Rezoning Petition Review

Rezoning Petition #: 20-66

Location of Property: Approximately 3.62 acres located along the north side of Sardis Rd, east of Sunnywood Ln and south of Watergate Rd.

RZ-1.0

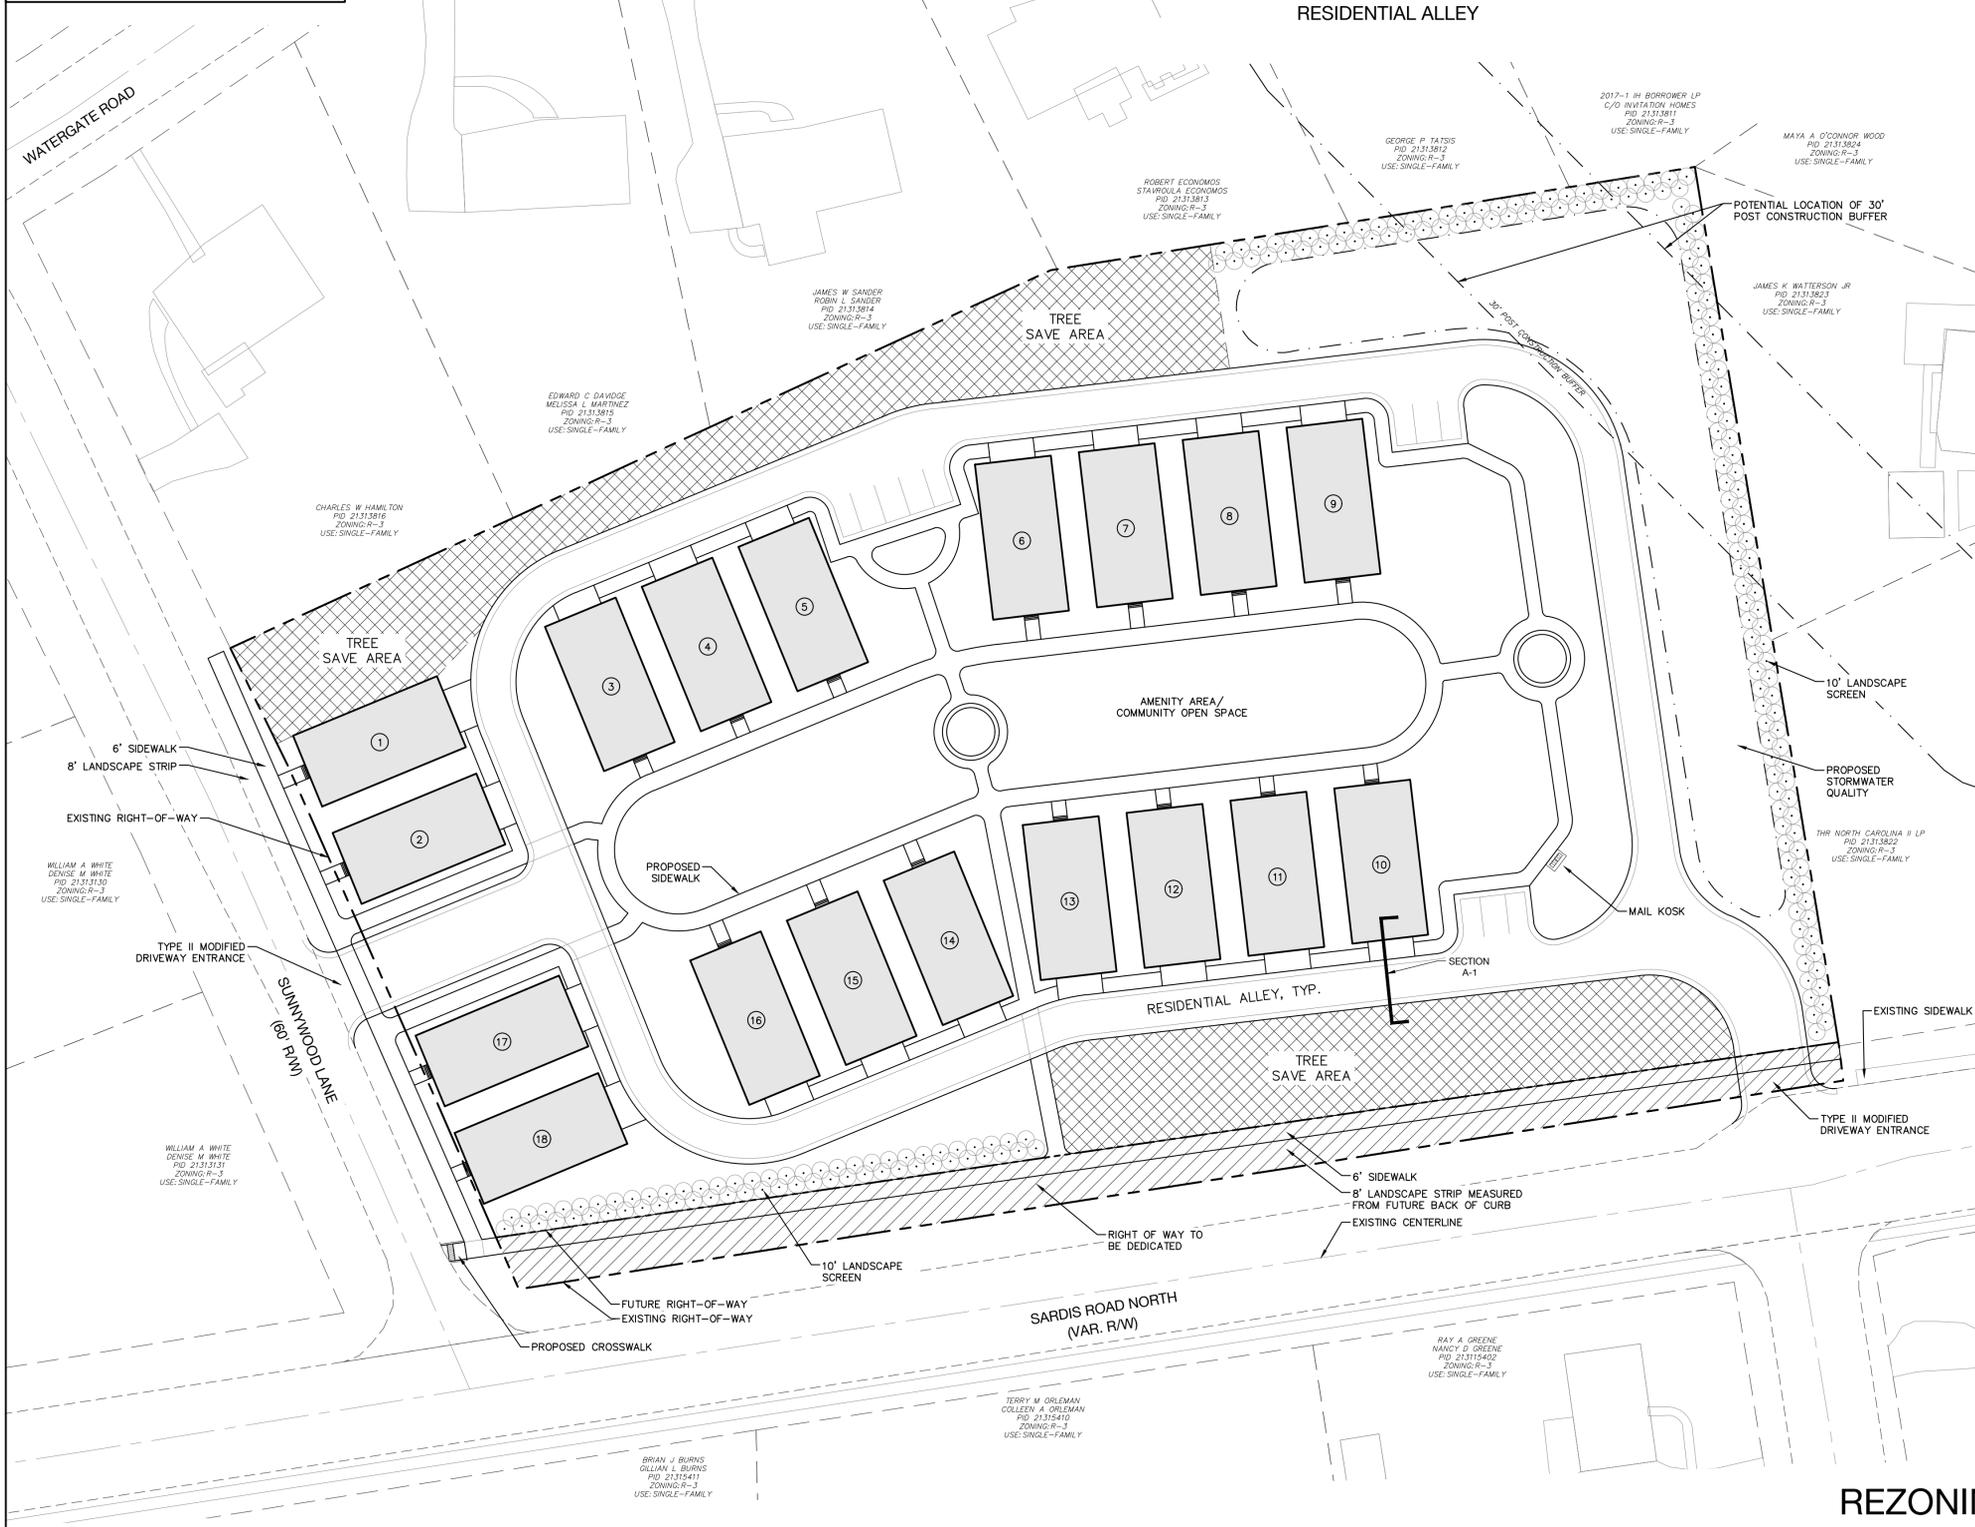
Concerning Storm Water: Please include the following note under Environmental Features:

- *The petitioner shall analyze the adequacy of the existing storm water conveyance on the adjoining parcels to and including Watergate Rd. If the existing storm water conveyance on the adjoining parcels is found to be inadequate, the Petitioner shall make a good faith effort with the property owner(s) to improve the storm water conveyance or mitigate the storm water discharge onto the adjoining parcels.*
- *Development within any SWIM/PCSO Buffer shall be coordinated with and subject to approval by Charlotte-Mecklenburg Storm Water Services and mitigated if required by City ordinance. Petitioner acknowledges intermittent/perennial stream delineation reports are subject to review and approval upon submission of development plans for permitting and are not approved with rezoning decisions.*
